EPC STORMWATER REVIEW COMMENTS
IN ORANGE BOXES WITH BLACK TEXT

CATHEDRAL ROCK CHURCH Grading & Erosion Control Plans Tract A, Struthers Ranch Filing No. 2 El Paso County, Colorado

GEC PLAN
TITLE SHEET

HORZ. SCALE: 1"=30'	DRAWN: PV
VERT. SCALE: N/A	DESIGNED: JPS
SURVEYED: RIDGELINE	CHECKED: JPS
CREATED: 05/27/20	LAST MODIFIED: 09/23/24
PROJECT NO: 082401	MODIFIED BY: PV
SHEET:	<b>C1.1</b>

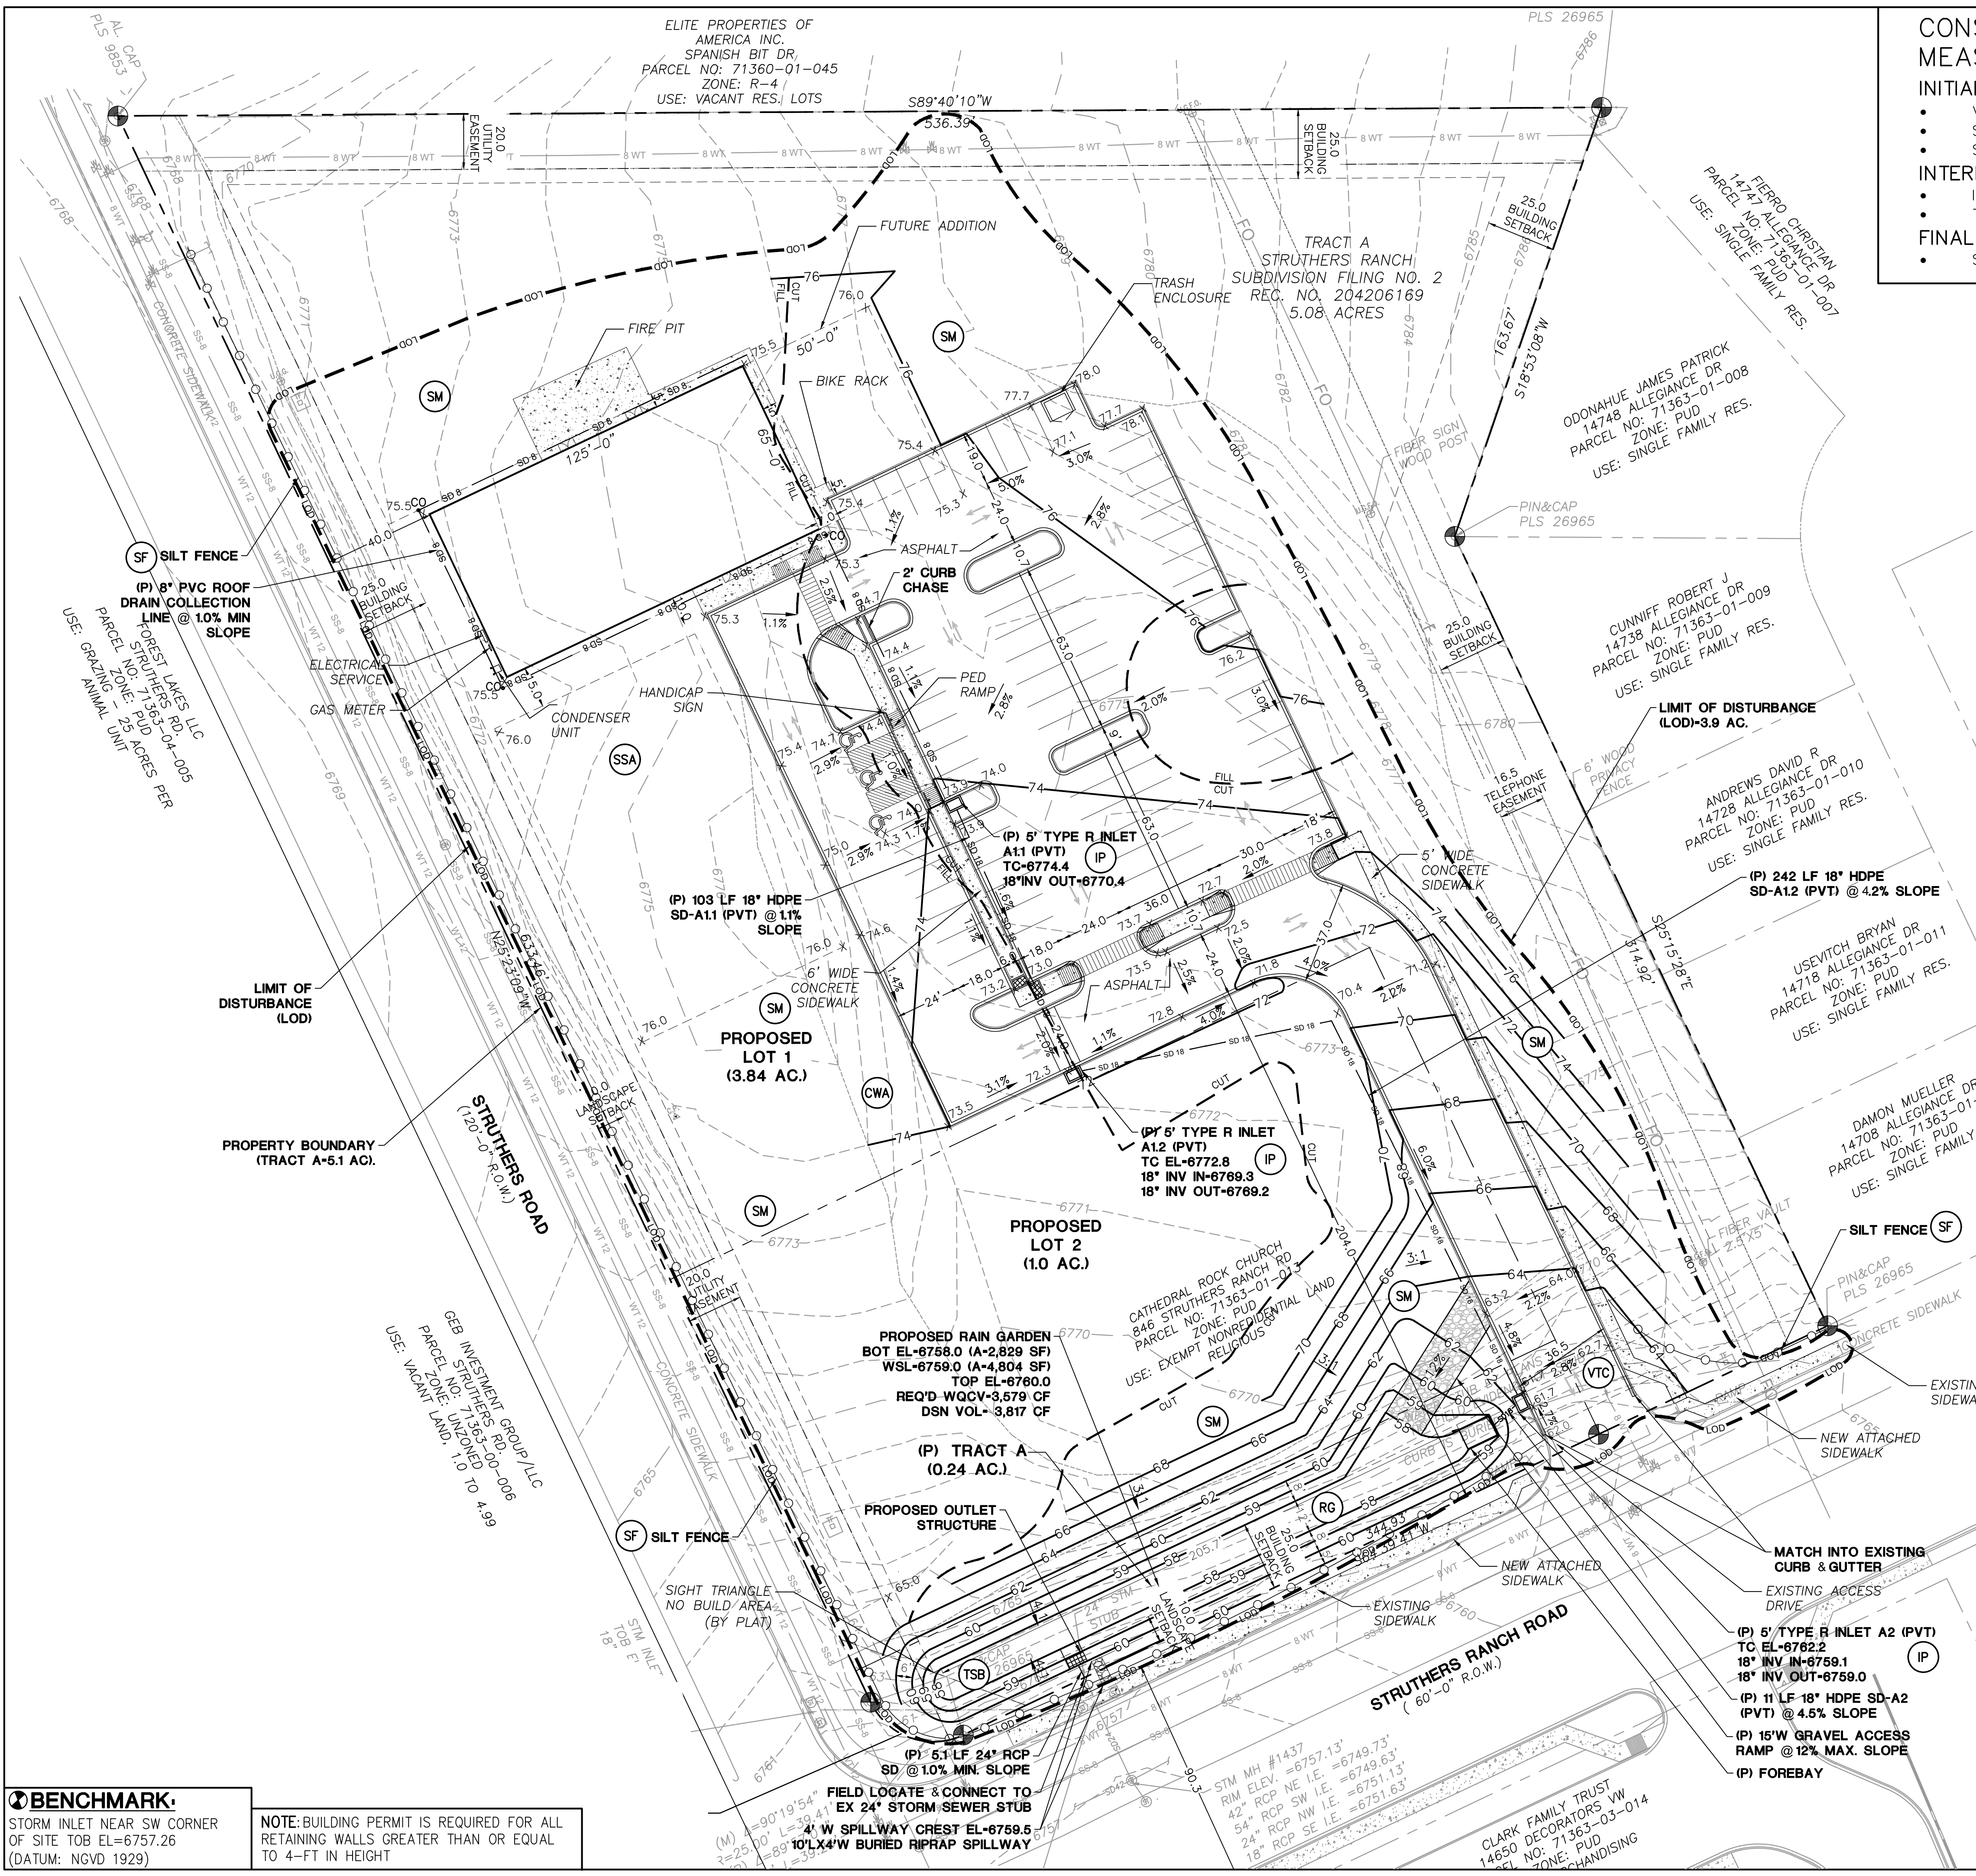
Show drainage flow arrows in plan view
